Rezoning Transportation Analysis

Petition Number: 2020-066

General Location Identifier: Tax ID 21313828

Date	Description
5/18/20	First Review (MM)
6/26/20	Second Review (LJensen)

RZ-1.0

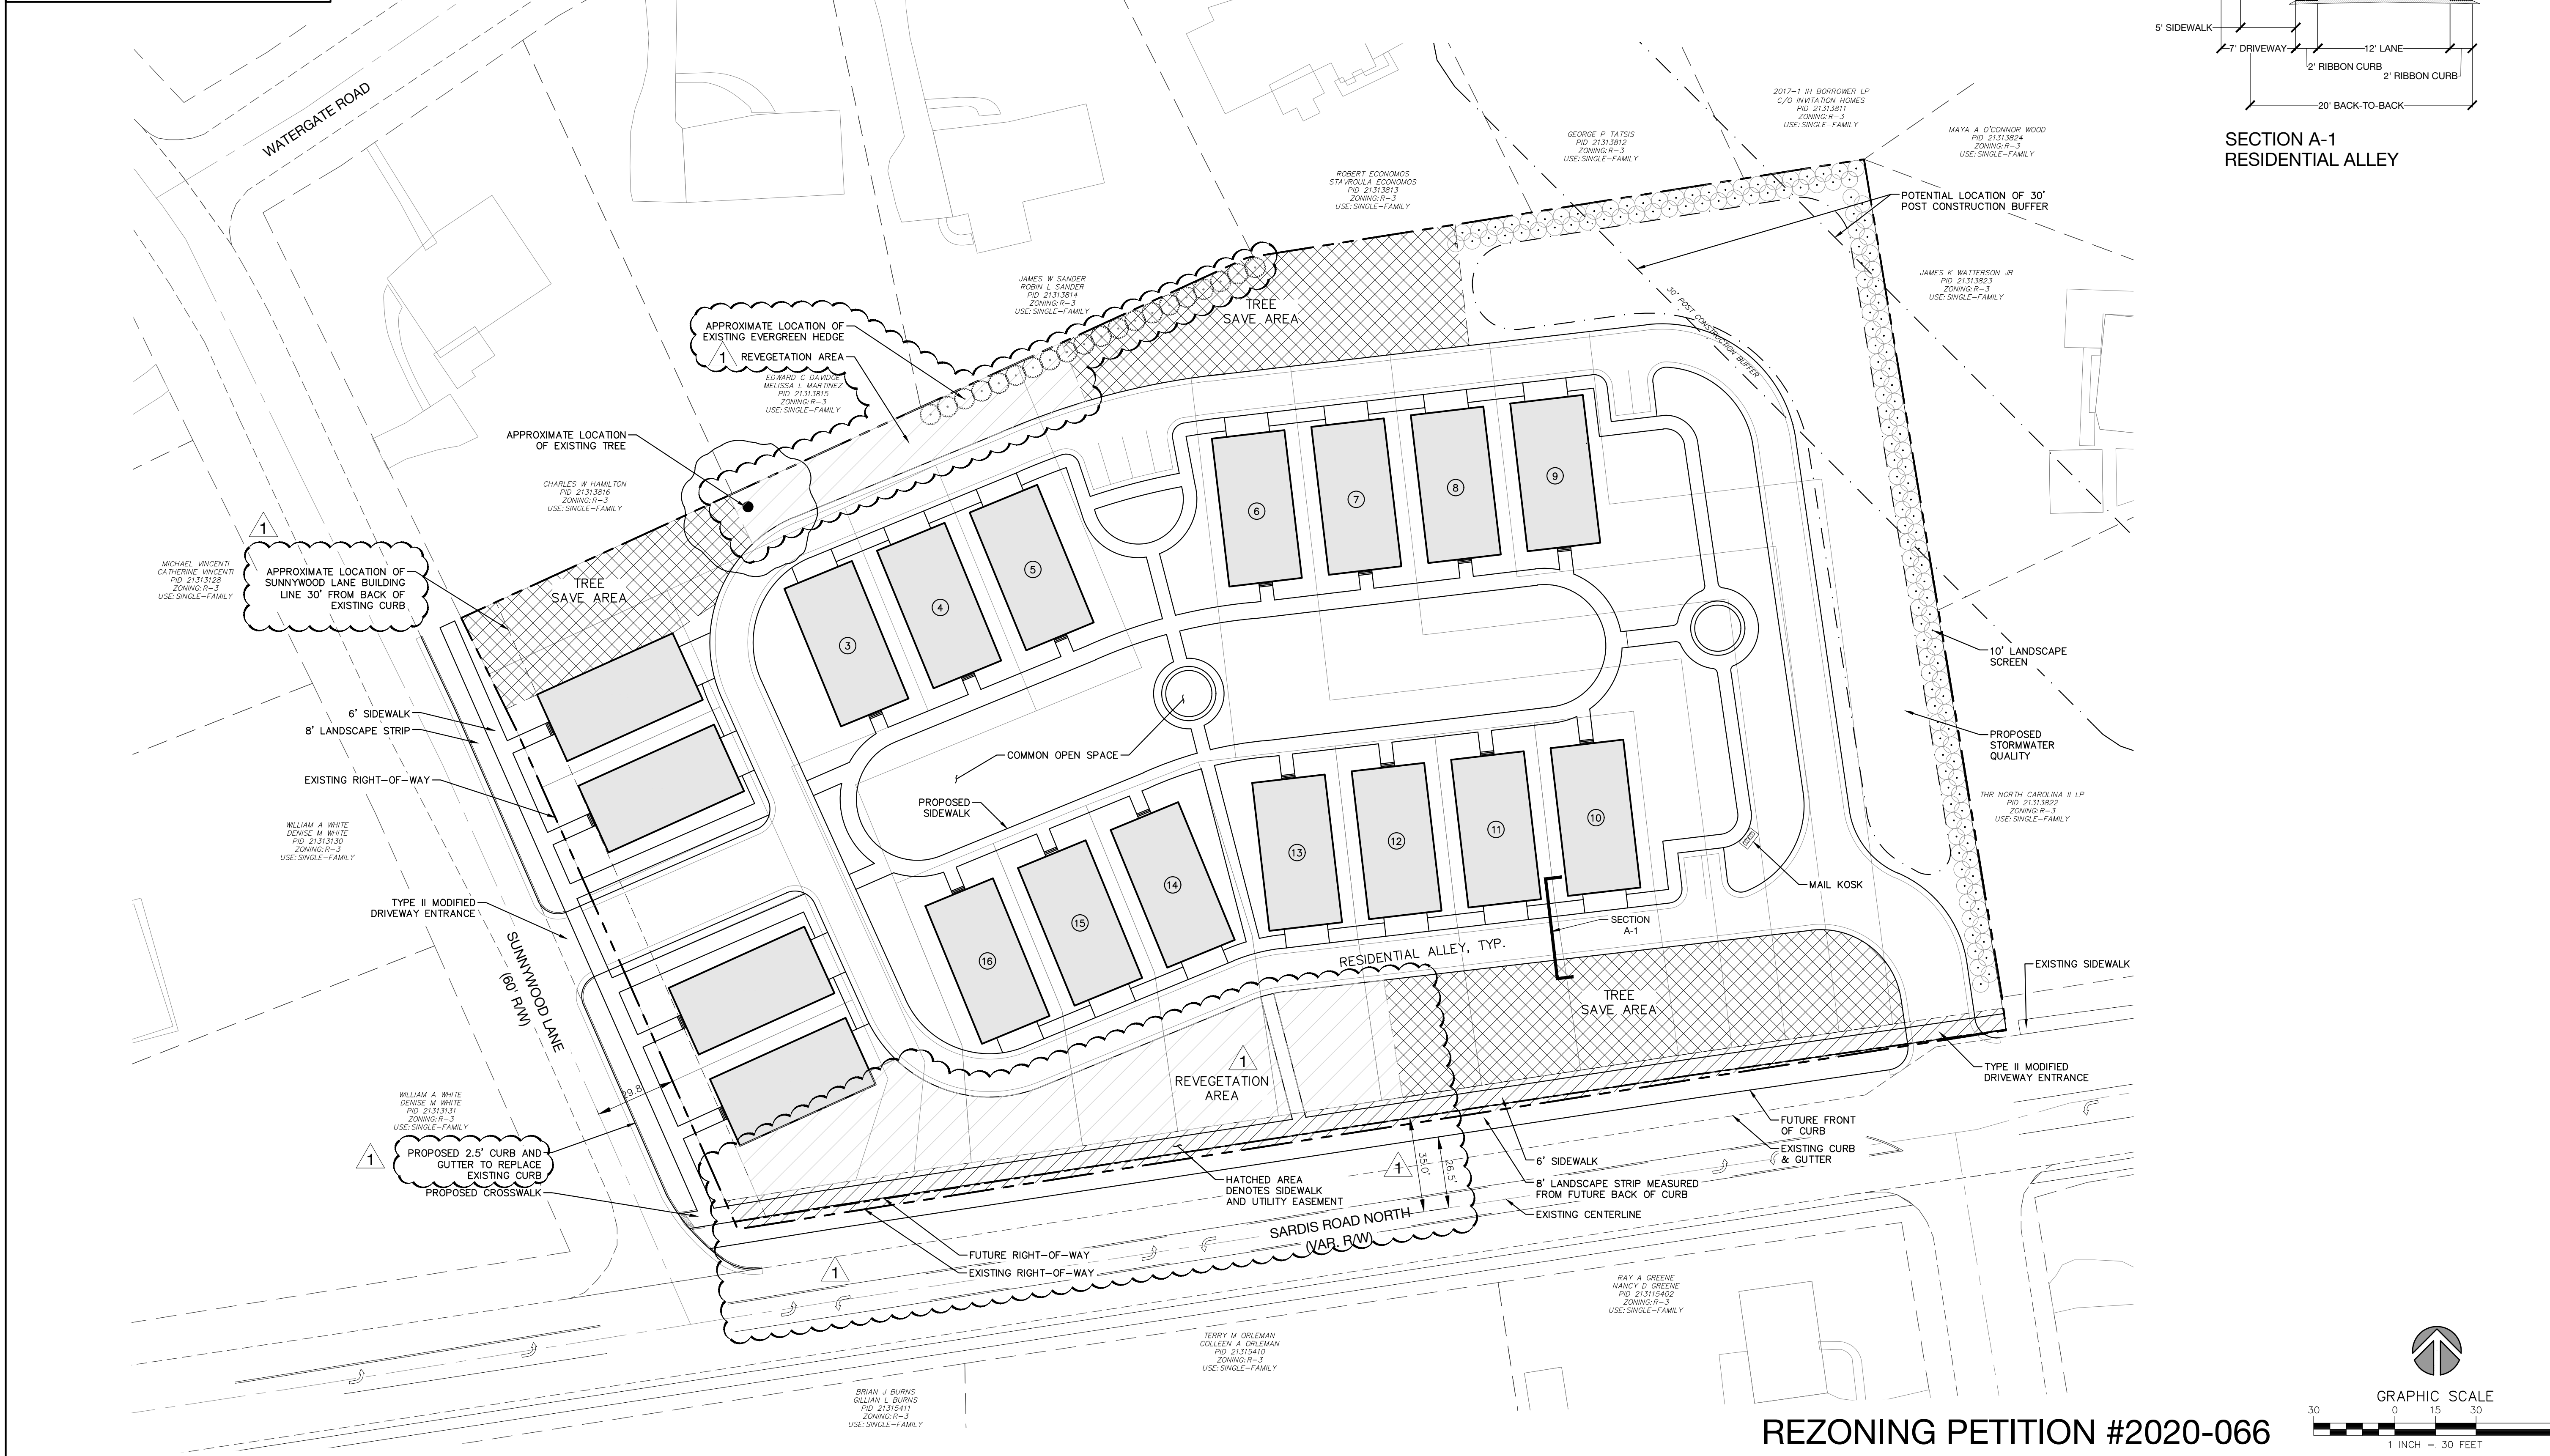
The site plan should show the curb and gutter labeled and dimensioned from the centerline for each road.

5. The petitioner should revise the site plan and conditional note (s) to state that the Petitioner agrees to pay in lieu or to install a pedestrian hybrid beacon (PHB) at the pedestrian crossing described in comment 4. Traffic volumes and speeds on this part of Sardis Rd. North are high enough that a pedestrian refuge island alone is insufficient. (Revised 08/25/2020)
6. ~~**Resolved** Sample format for comment that is resolved~~
